From: Ruiz, Nina
Sent: Friday, June 6, 2025 11:54 AM
To: McCormick - DNR, Brian
Cc: Nicholas Jokerst; districtmanager@epccd.org; heritagebellefarms@gmail.com
Subject: RE: Frankstown Parker FPE-2 Dam

I am reaching out regarding the Deim Subdivision, which contains the Frankstown Parker Dam. You received a referral from EPC and are aware of the proposed development, but I thought I would give you a quick overview since I am sure you deal with many properties. The property is located [here](#).

I am reaching out because EPC is looking for something in writing indicating you are OK with driveway locations. Can you please review the attached drawing with red text to indicate driveway access and confirm?

# DEIM SUBDIVISION

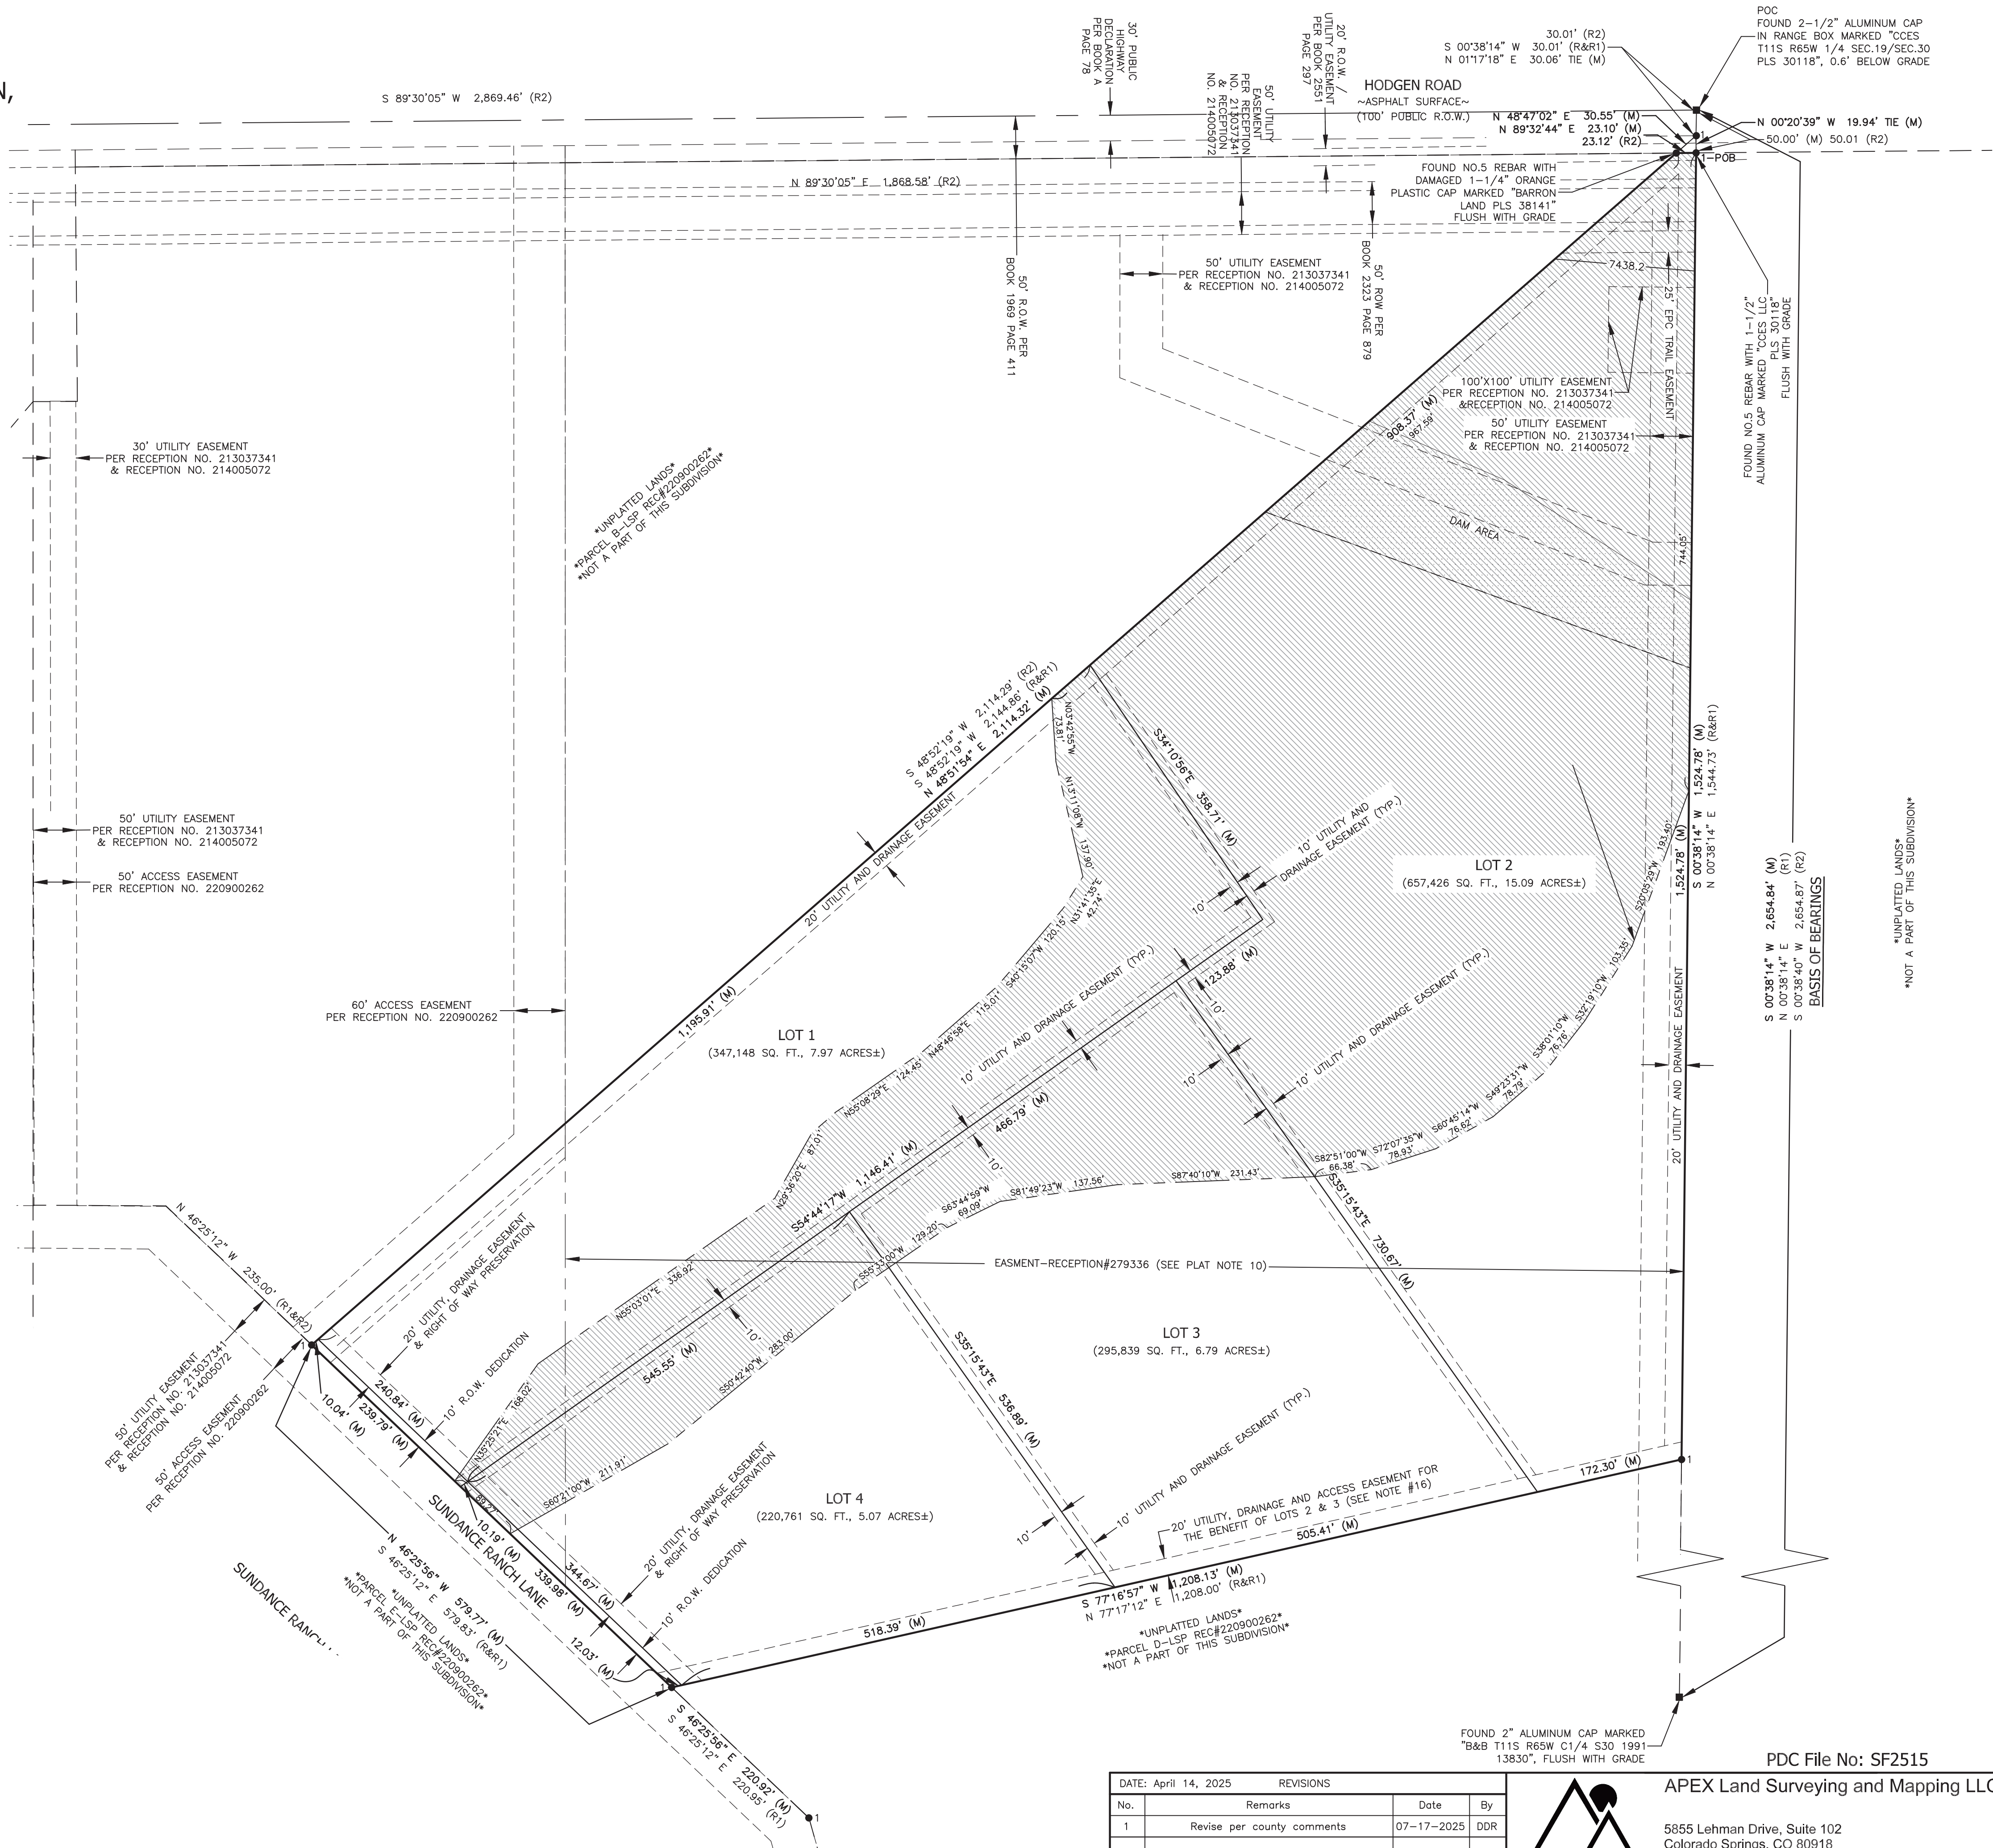
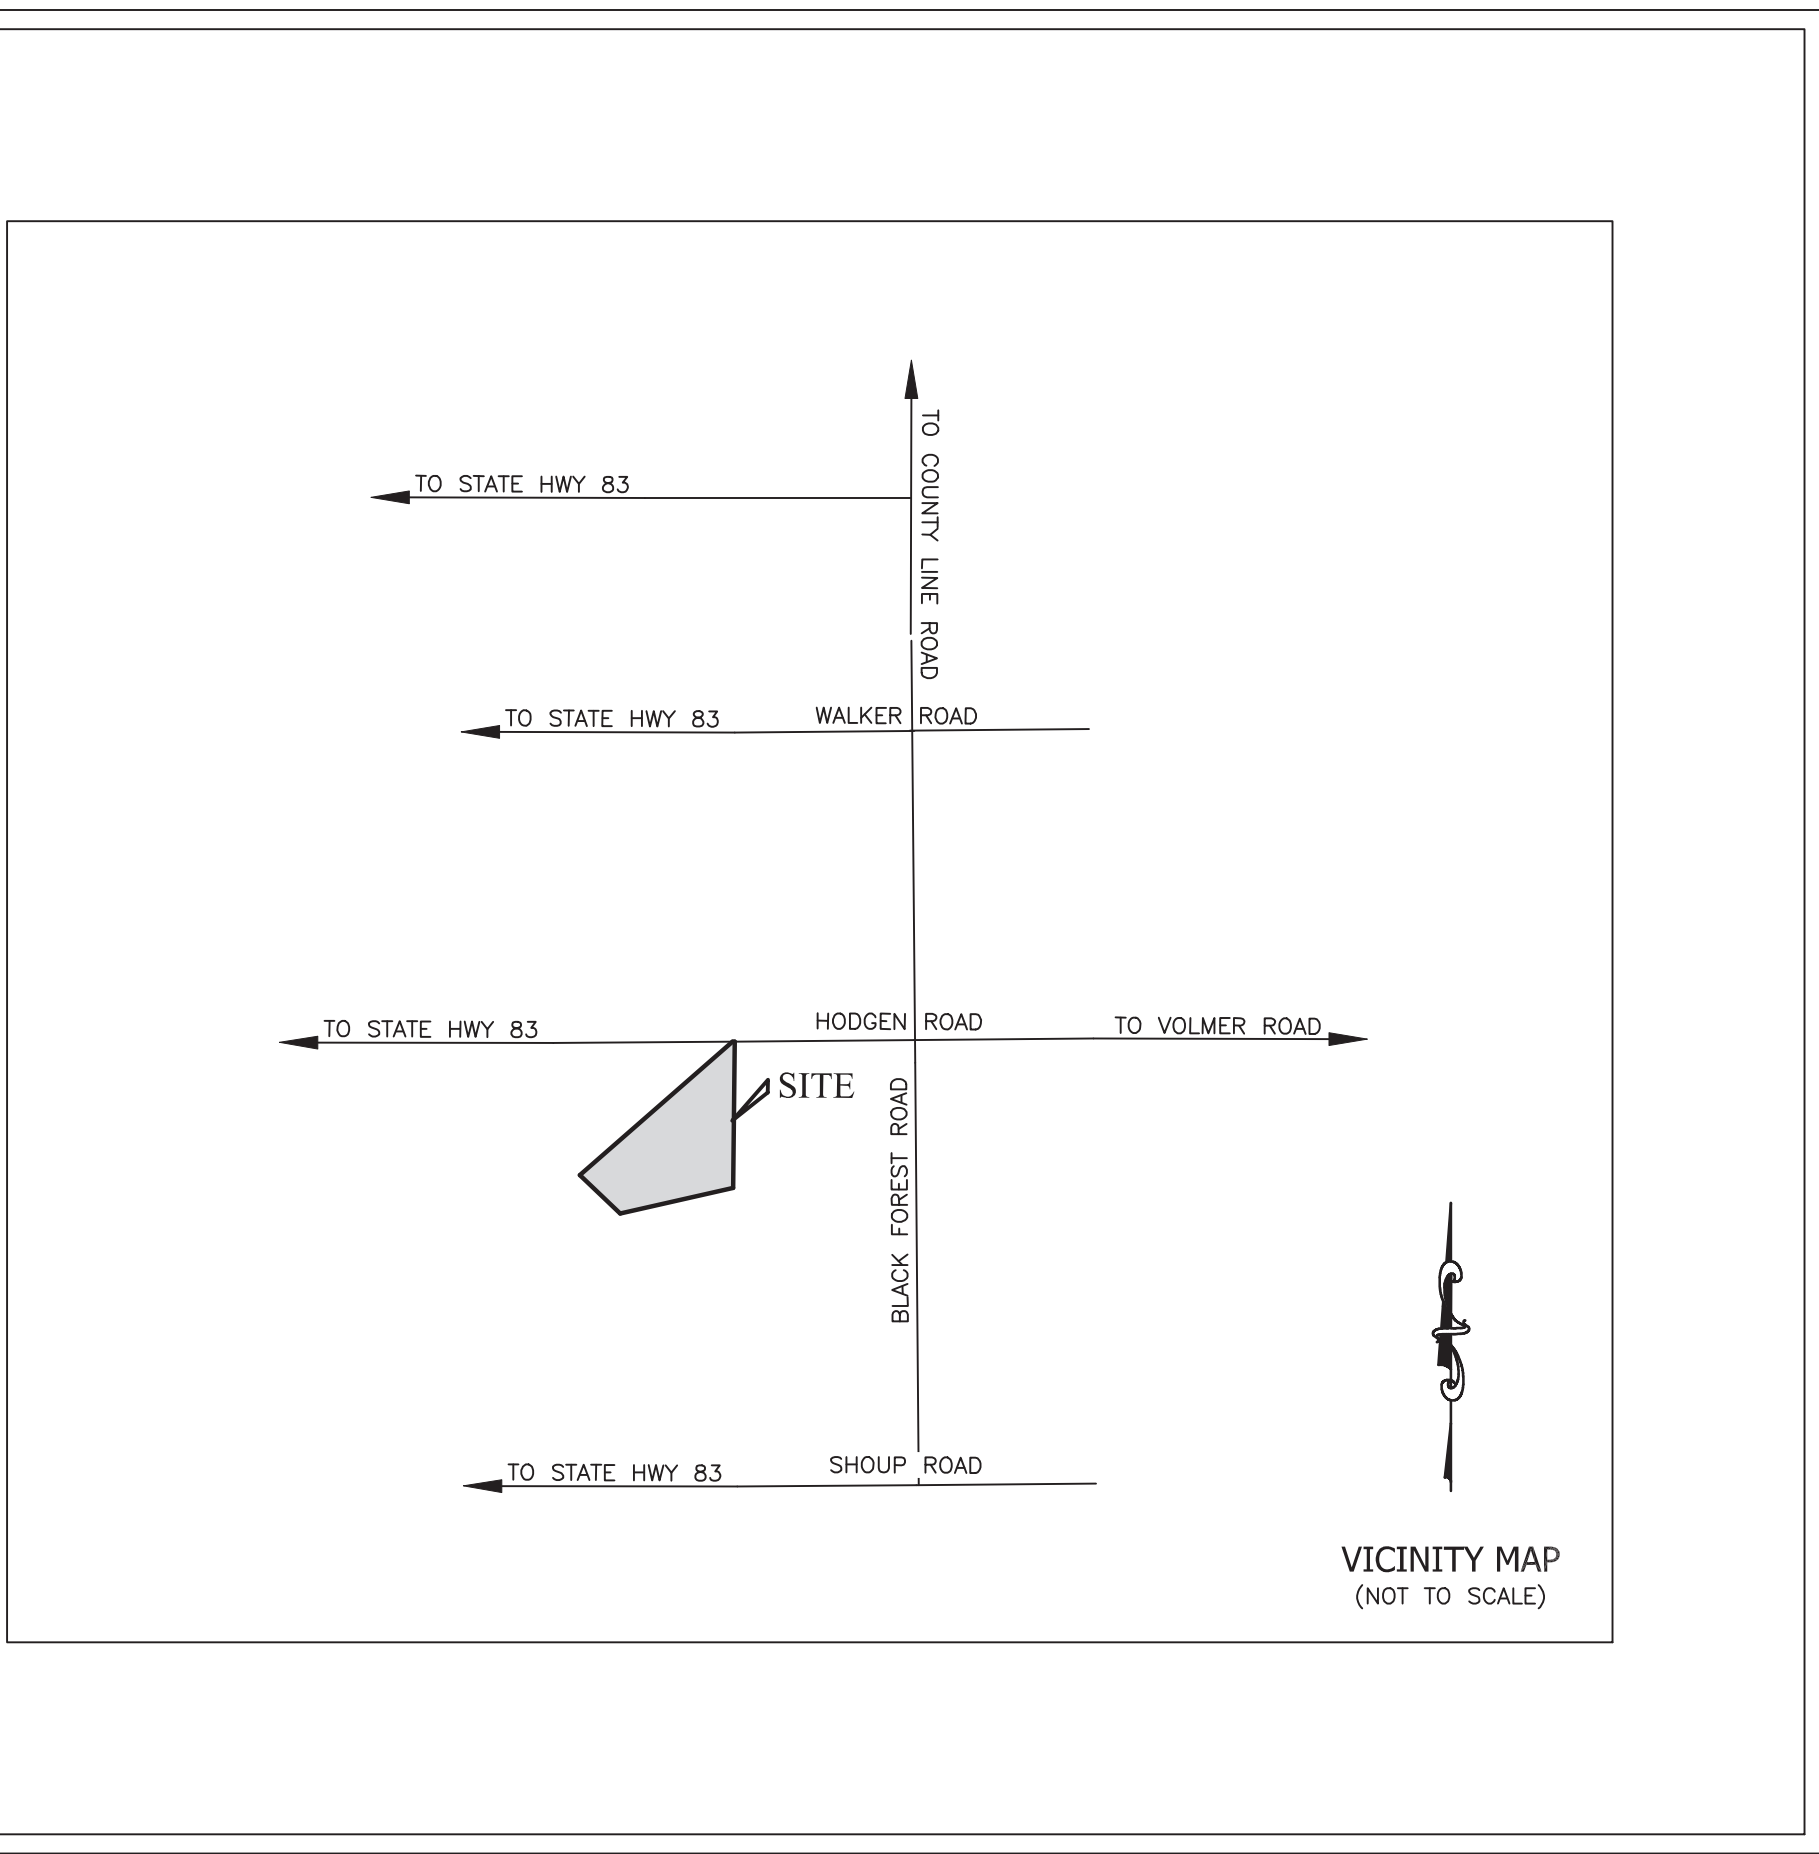
I have no concerns about the driveway locations shown on the provided plat as they are greater than 200ft from the dam, do not affect the safety of the dam, and are therefore outside of my jurisdiction.

I would caution that it does not appear that there is much buildable area on these lots above the level of the normal high waterline (the spillway crest) for this normally dry flood control dam. It appears that the floodplain / no build area shown on the plat does not extend to the elevation of the spillway crest however without seeing a grading plan and floodplain modeling I can't offer a determination. Anything built below the level of the spillway crest, and possibly the dam crest is at risk for flooding from filling of the reservoir when it performs its intended flood control function.

Thank you for the quick response! Nick (CCed) is aware of the discrepancy and updating the floodplain lines. Luckily, the lots are large and buildable area will remain to allow for dwellings. Have a wonderful week!
